M4-M5 SSI-7485-Mod-2 ROZELLE INTERCHANGE COMMUNITY COMMENT

Key issues:

Figure 4-7 Elevation: Indicative view of the shared user path bridge

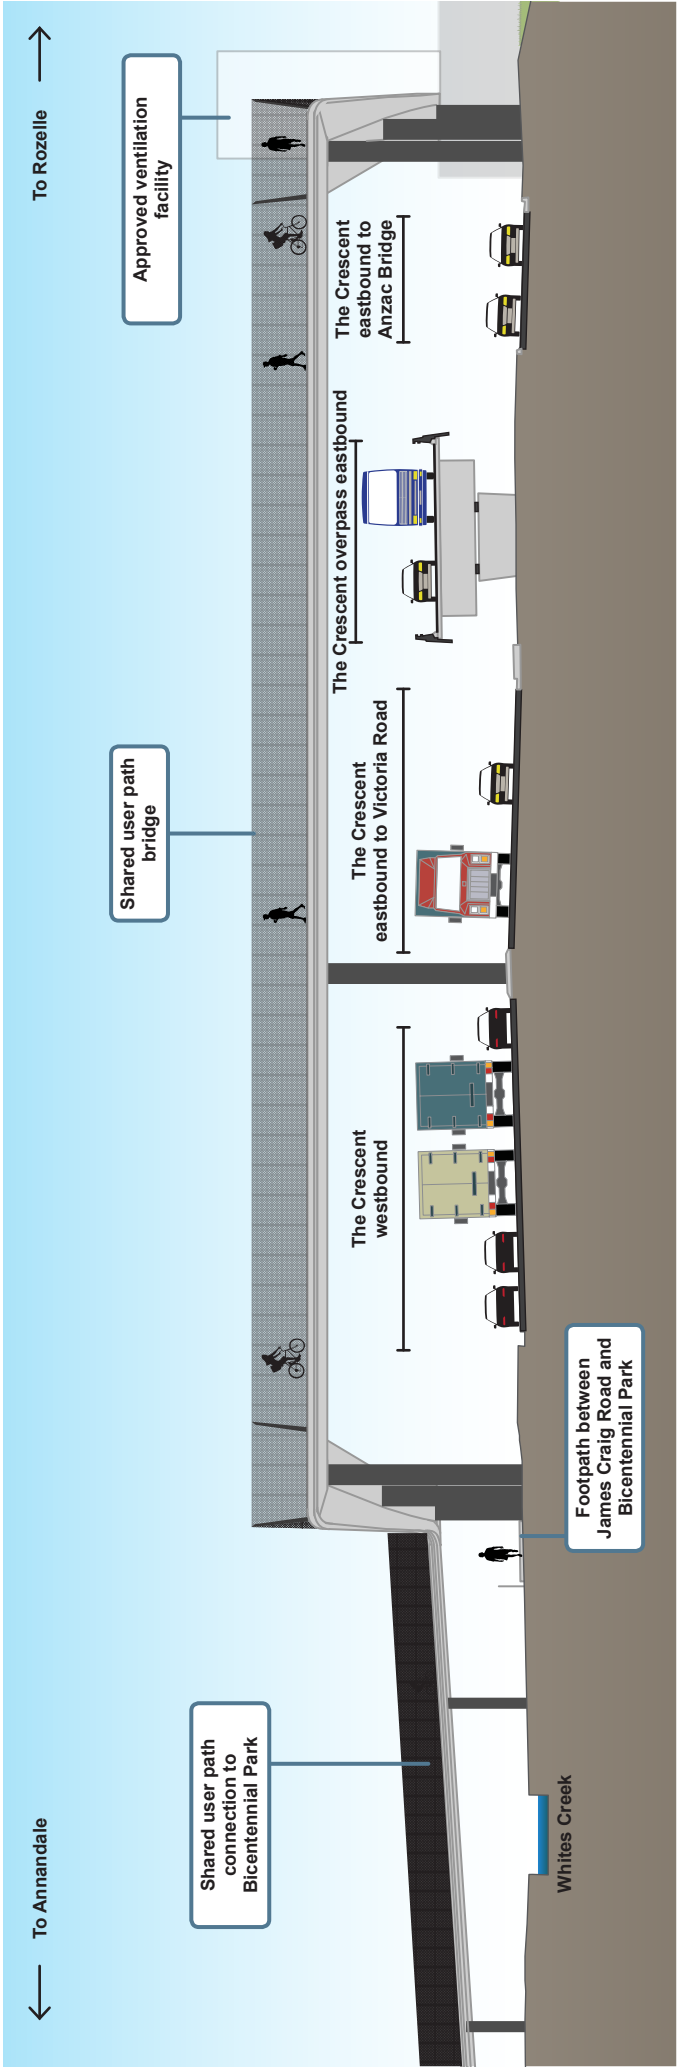
To provide the necessary clearance over the overpass, the additional cycle / pedestrian bridge is elevated an additional say 3.0m. At 1:21 to include landings that is adding approx 126m length to the overpass. [2x 63m]

Support beam is likely to look thicker than illustration given existing Beatrice Brush Bridge and similar recent bridges on Warringah Road

It has forced the relocation of the green bridge impacting all the related connectivity issues outlined in the previous section. It has also forced the introduction of a second bridge that is very long and high to get over the down ramp.
